DEVELOPMENT REVIEW BOARD  
TRANSPORTATION DEVELOPMENT

DRB Project Number: 2019-002184  
Guardian Storage at Osuna

SUBJECT: Site Plan

ENGINEERING COMMENTS:

SITE PLAN - DRB

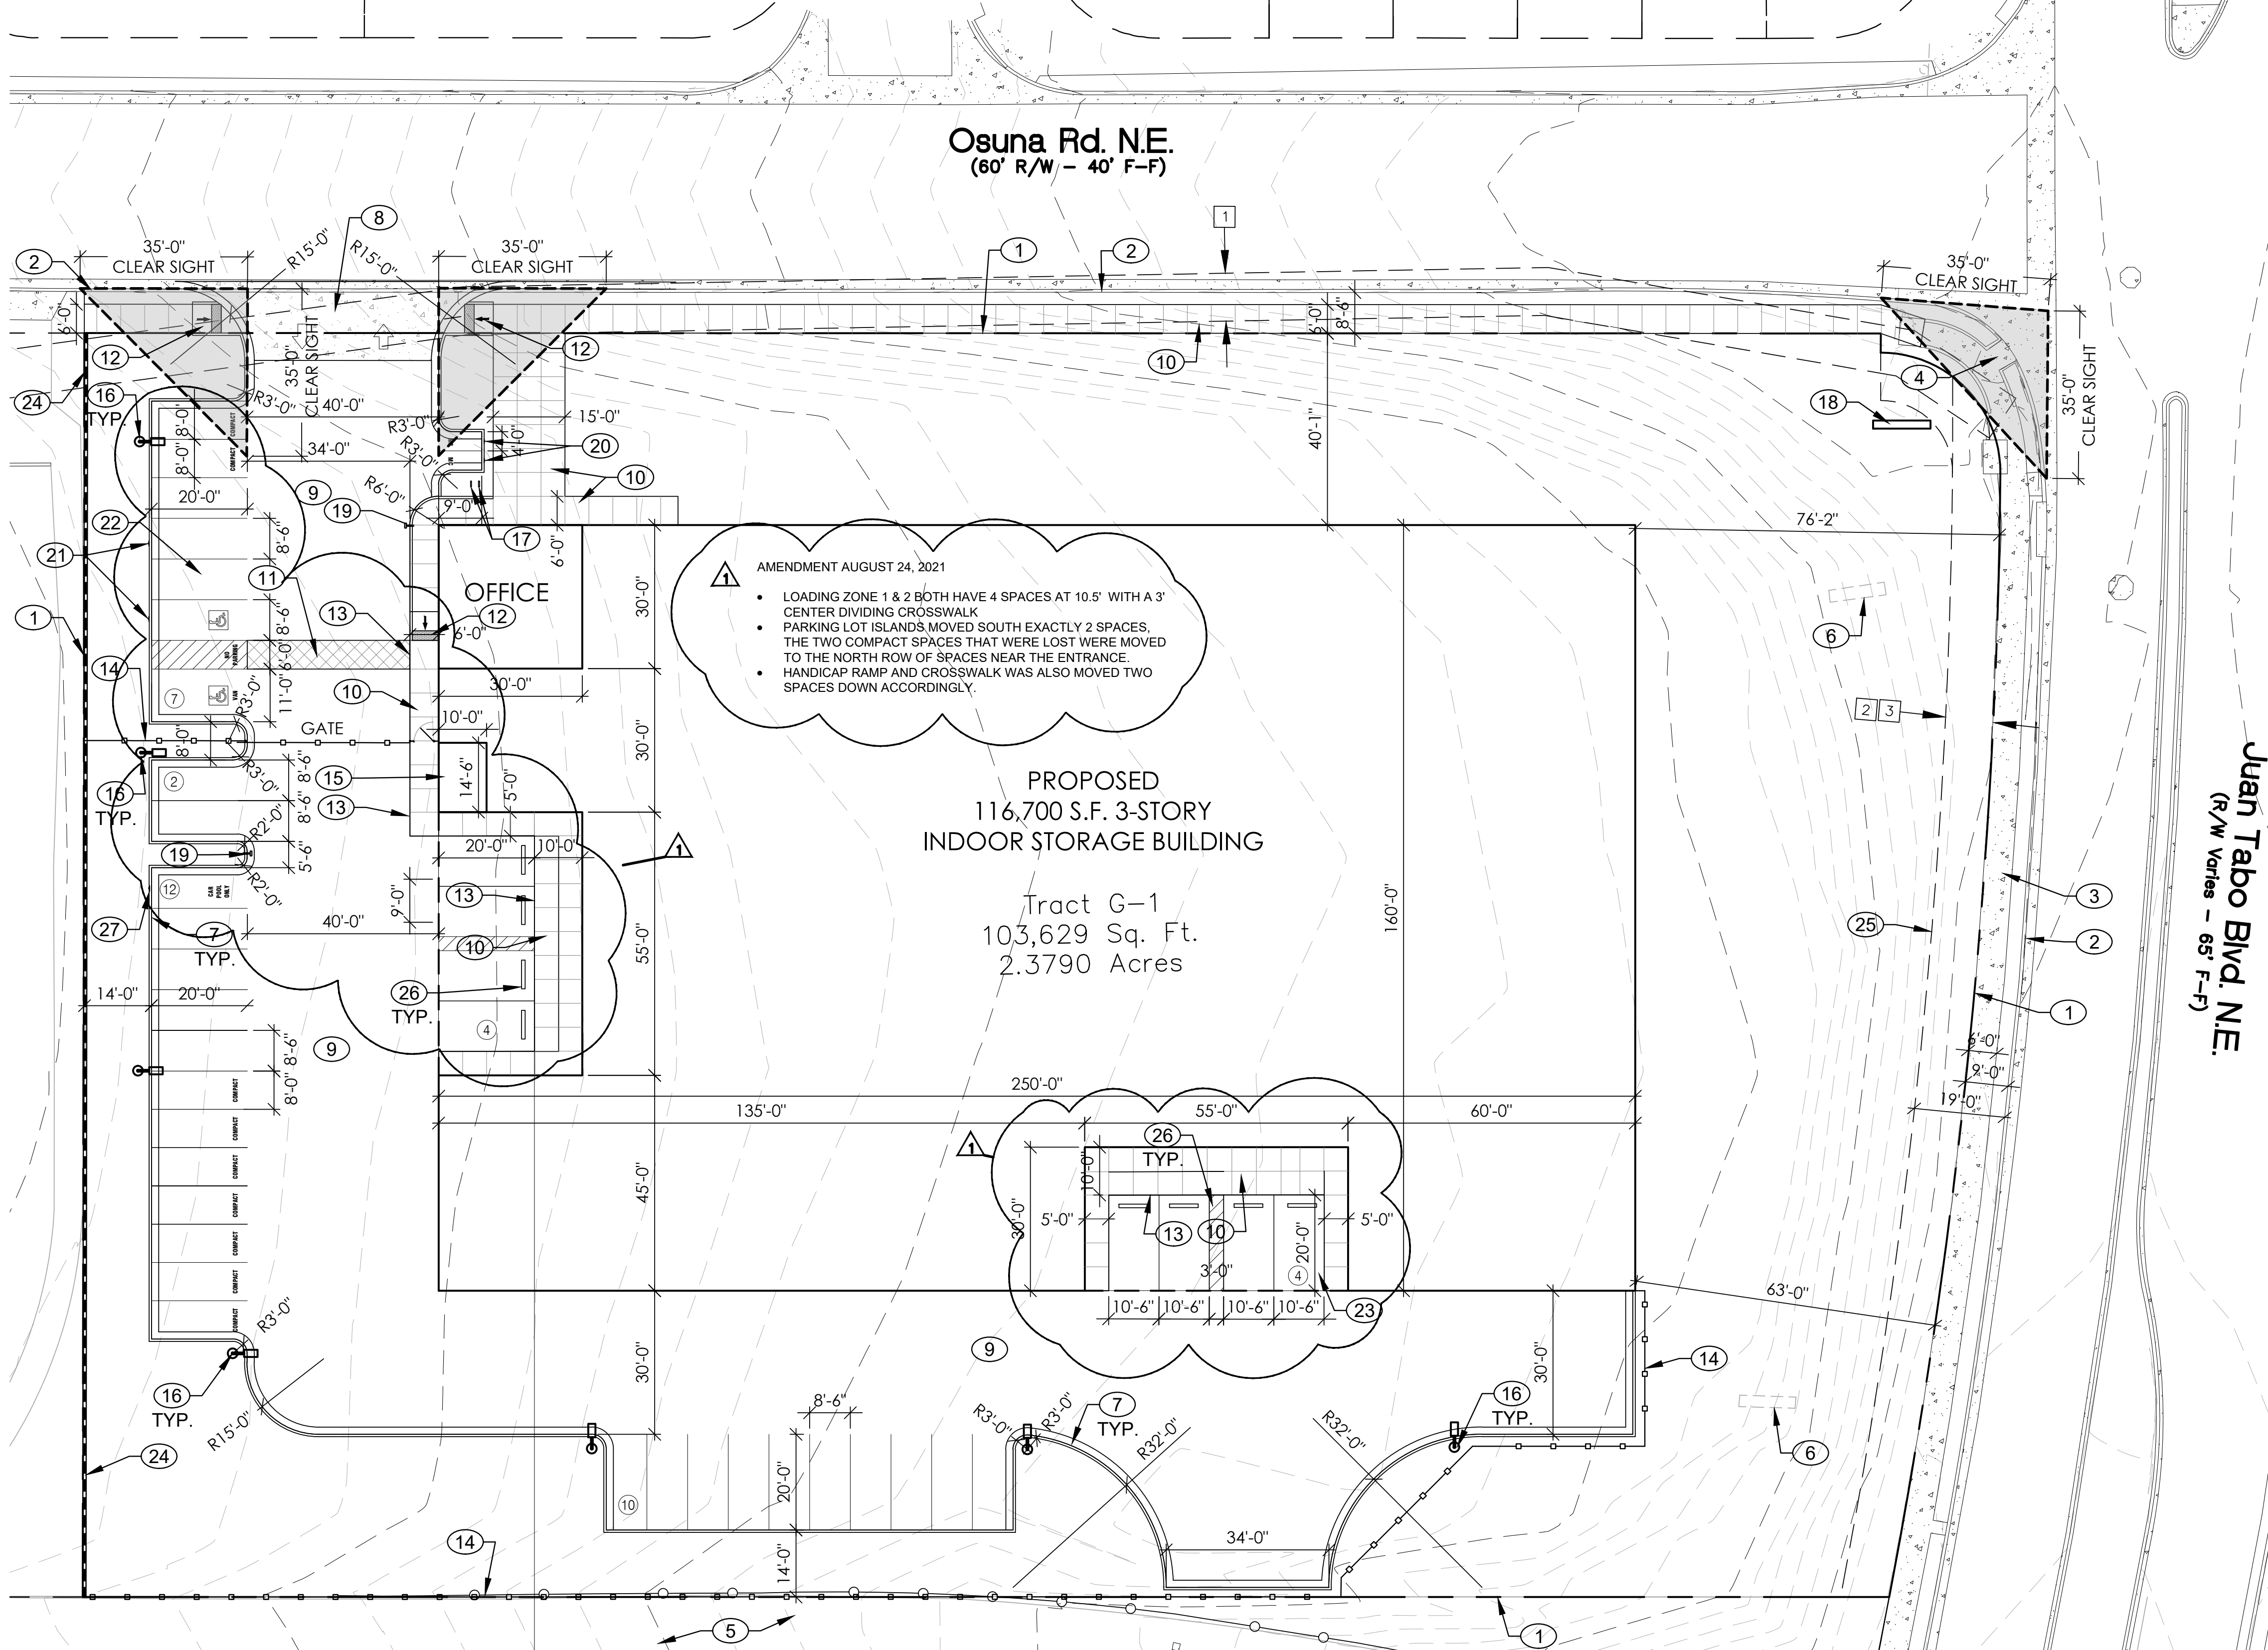
1. Dimension parking island radii.
2. Include architectural/Engineer's stamp on site plan.
3. For driveway detail cross-section showing the 1.3% cross-slope on Sheet 6 of 9, that should be a minimum of 4 feet wide to comply with ADA.
4. Unless this site plan is going to work order, call out COA standard details for drivepad and for sidewalk.
